RE: Brown and Jackson/ 4 G Farms Sewage Lagoon project

We have seen the Notice of Application, SEPA checklist and amendment to said SEPA checklist. We would like to comment **AGAINST** Kittitas County approving this project. This SEPA checklist that was submitted to CDS is filled out so vaguely and incorrectly that CDS should **NOT** approve the project.

**BROWN & JACKSON**  
 Land Application Site  
 Preliminary  
 Site Map  
 Kittitas County  
 Washington

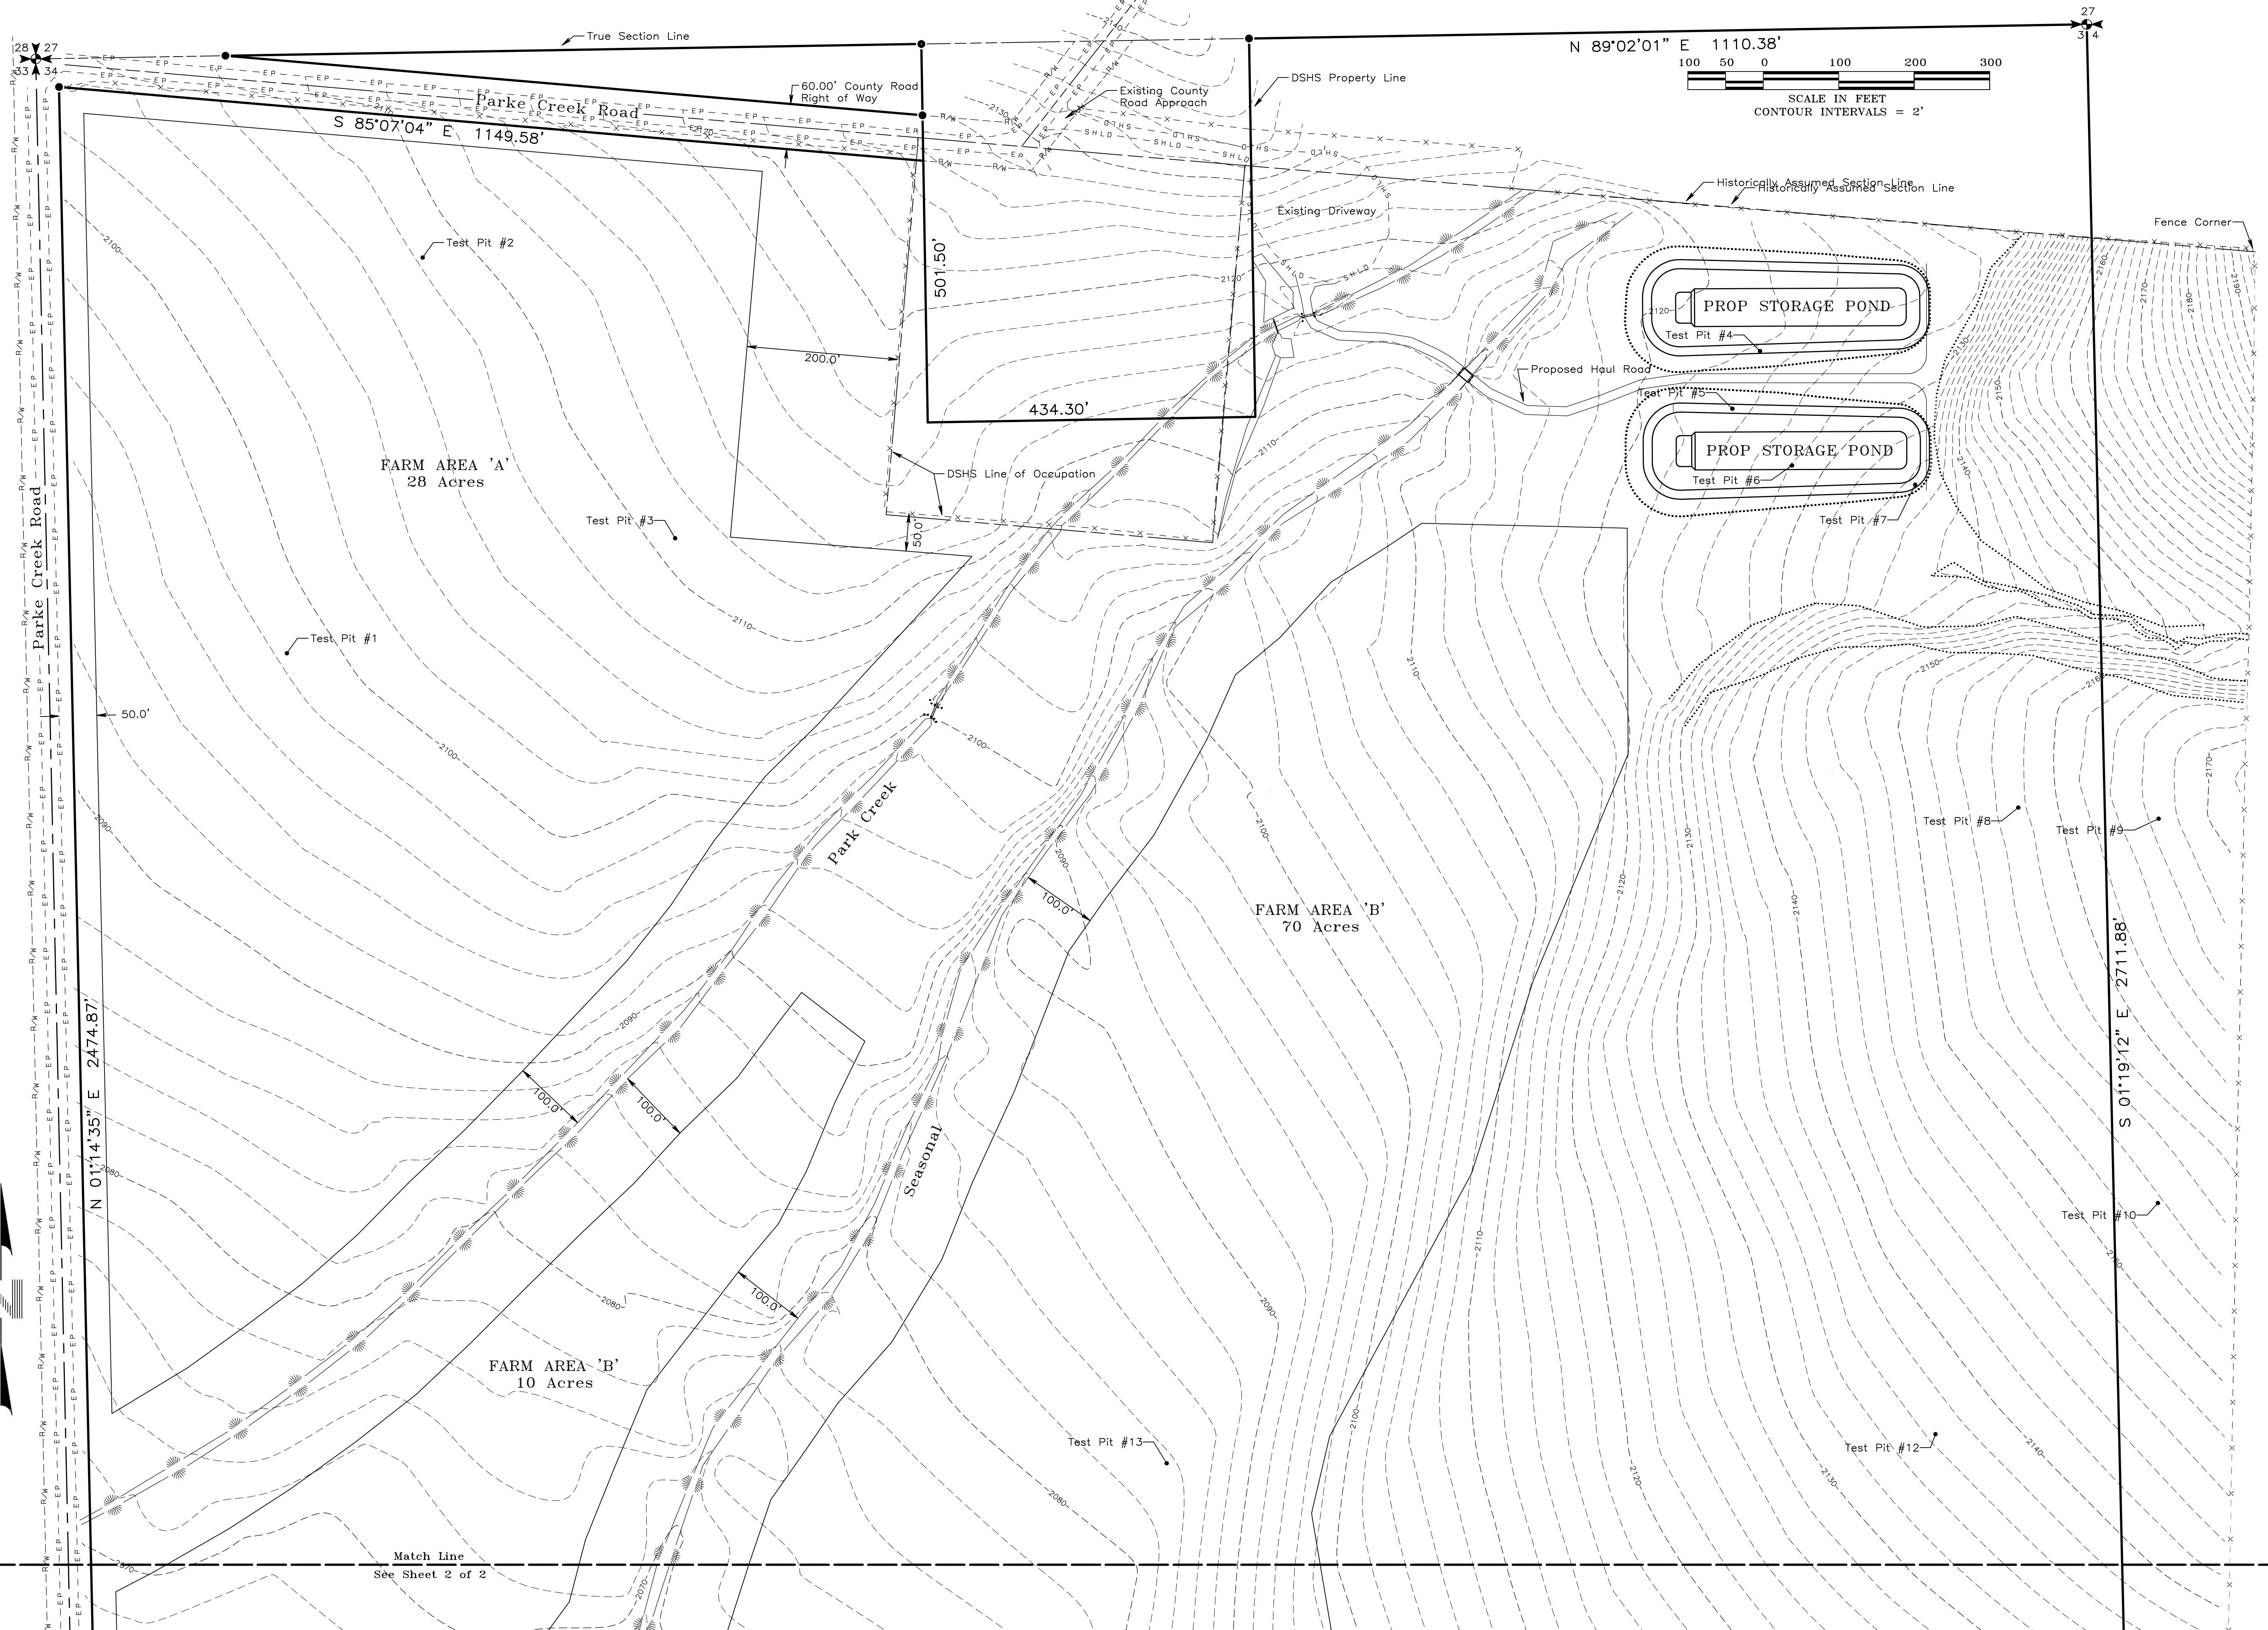
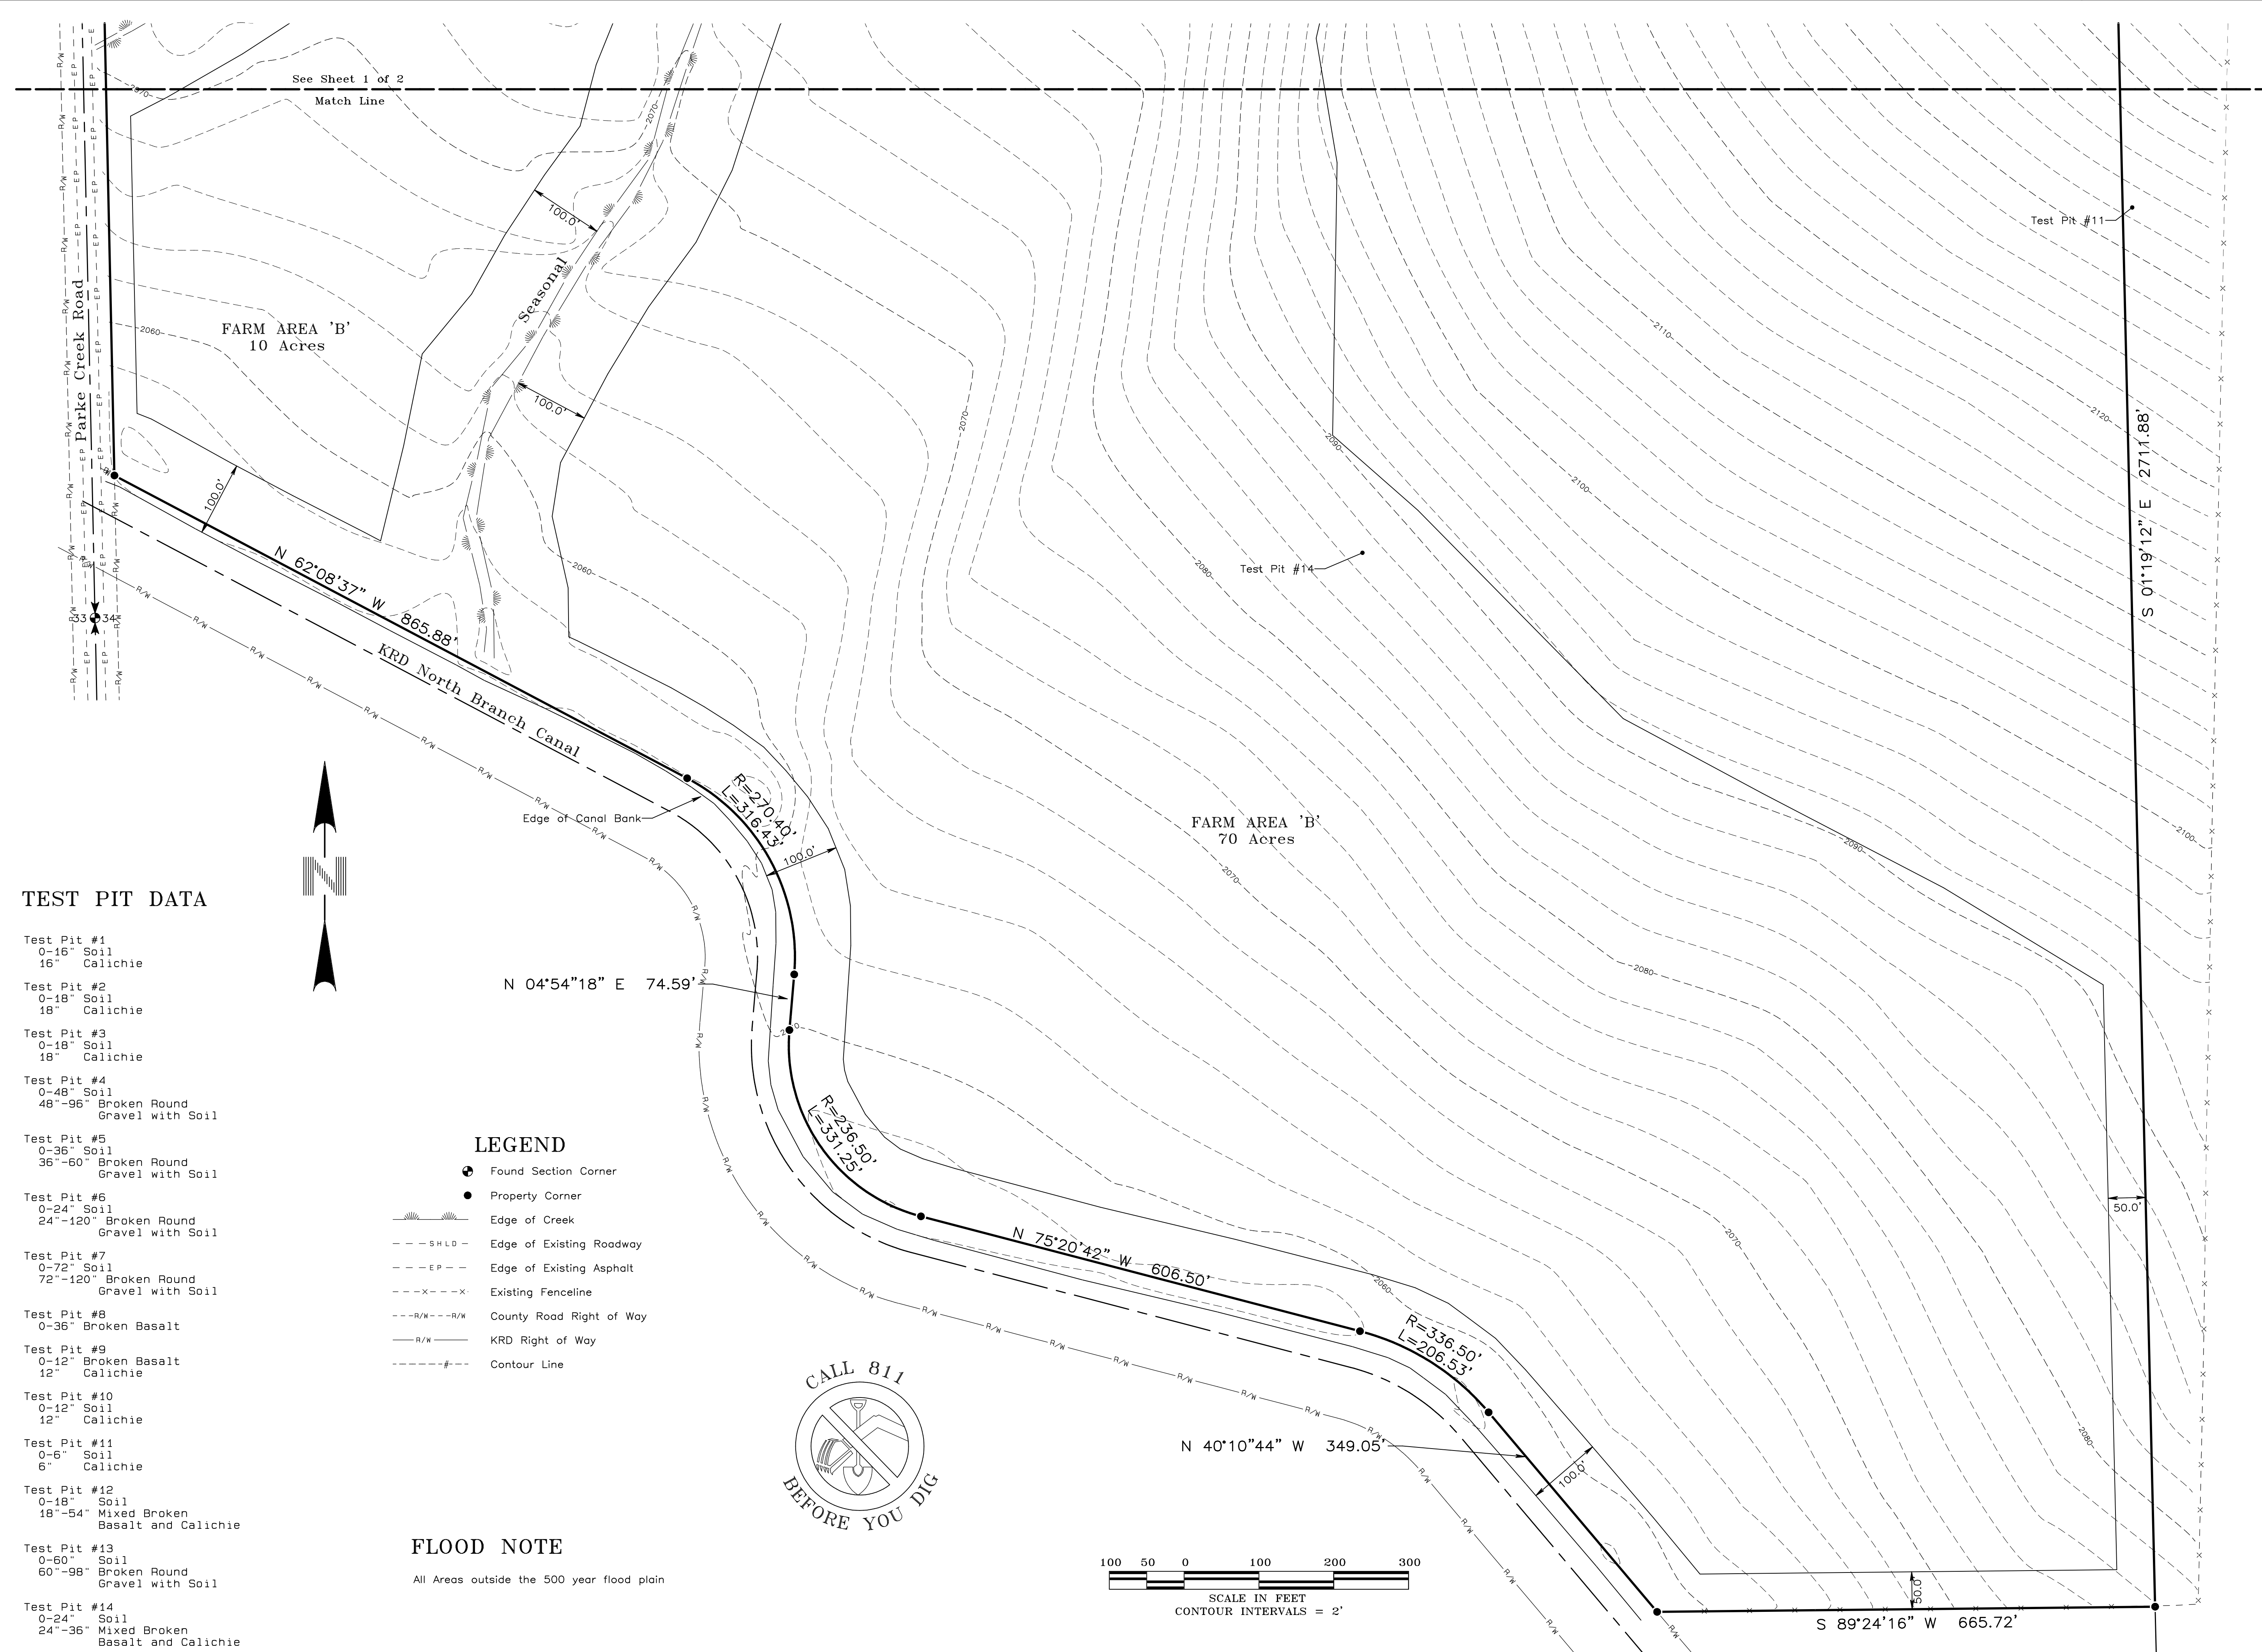
They state construction will be started “immediately upon approval”. The test sites labeled on the proposed plan appear to have already been taking place as well as the “existing bridge” (over and through Parke Creek) that was built in a day on May 13th without permitting. How convenient that they could label it as an “existing creek crossing” one month before their application was submitted.
